The number of bedrooms will increase from 4 to 5. It should be noted that Northamptonshire Parking Standard for 4+ beds are 3 spaces per dwelling plus 1 (total 4). Therefore I assume the existing car parking is adequate. I have nevertheless shown four 3 x 5.5m spaces on the site plan. Revised drawing number 22.01.01A is attached.

I am validating the above planning application for 25 Mill Road, Yarwell and would like to suggest a small change to the description to: "First floor side extension to allow for creation of annexe for ancillary use to the main dwelling"

SITE PLAN 1:500

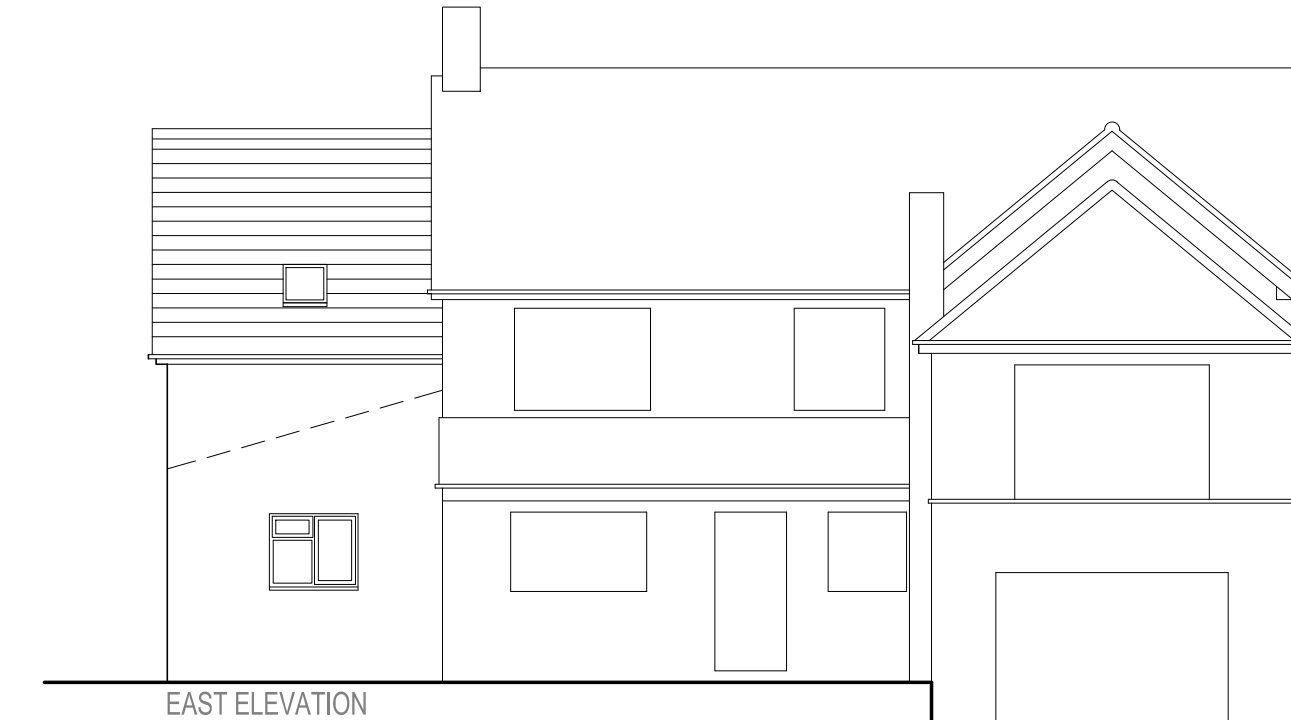
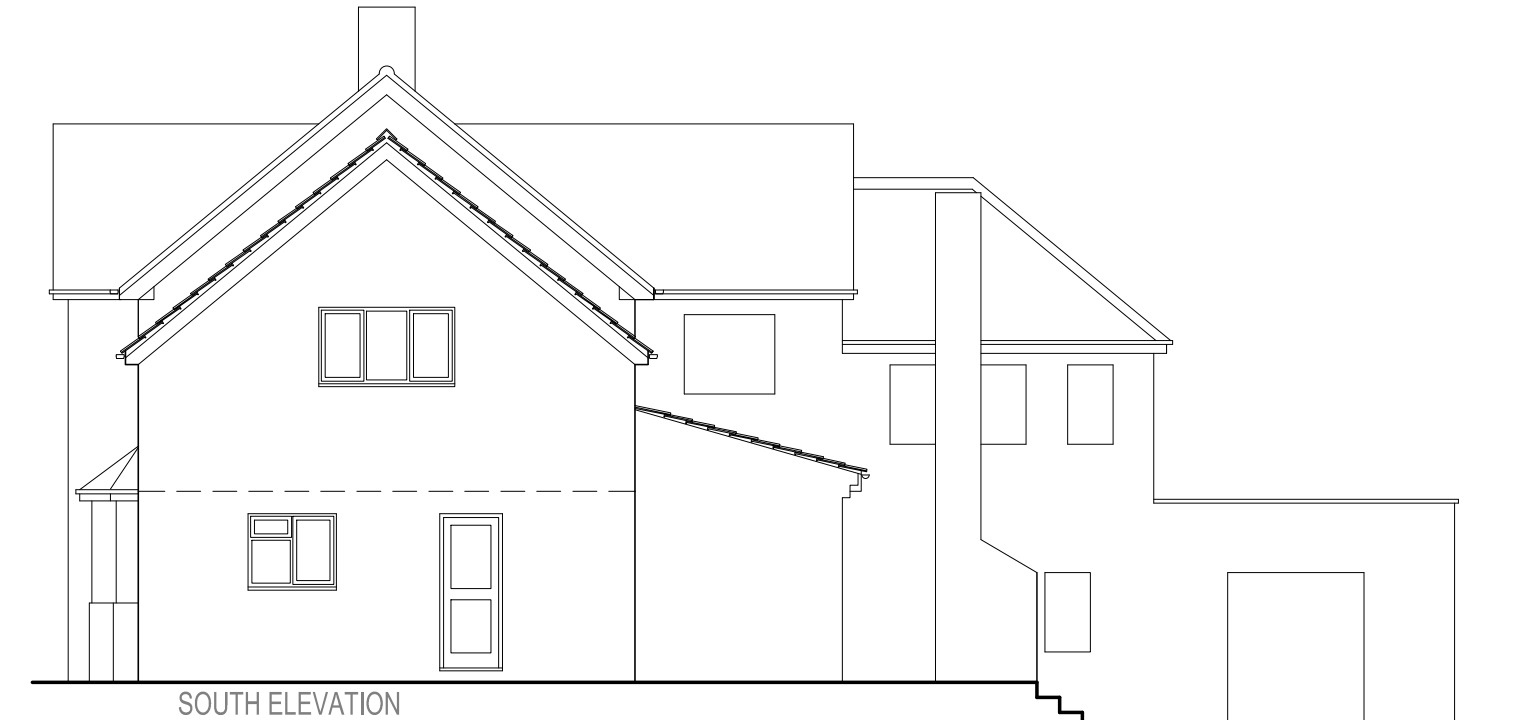
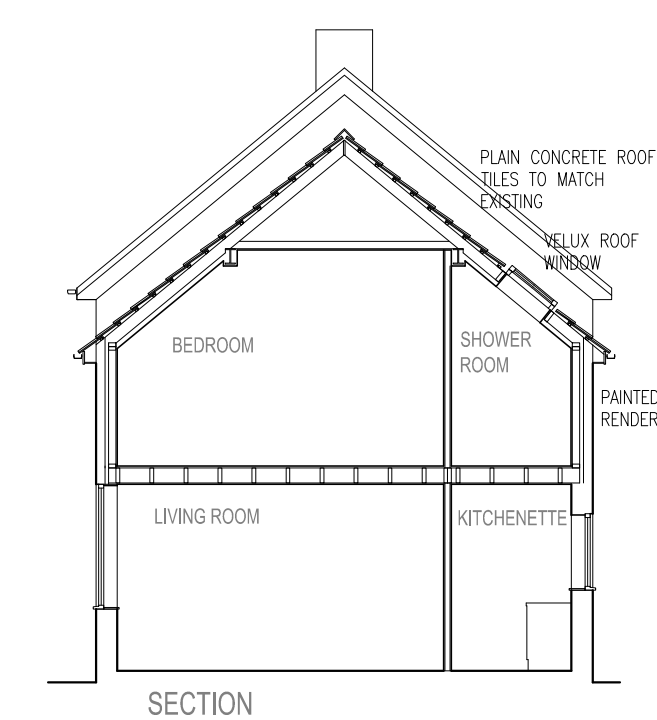
Additionally, due to the increase in the number of bedrooms we will be consulting the highways authority who will need to see compliance with parking requirements, therefore it would be advisable to provide an amended site plan showing the existing/proposed parking provision.
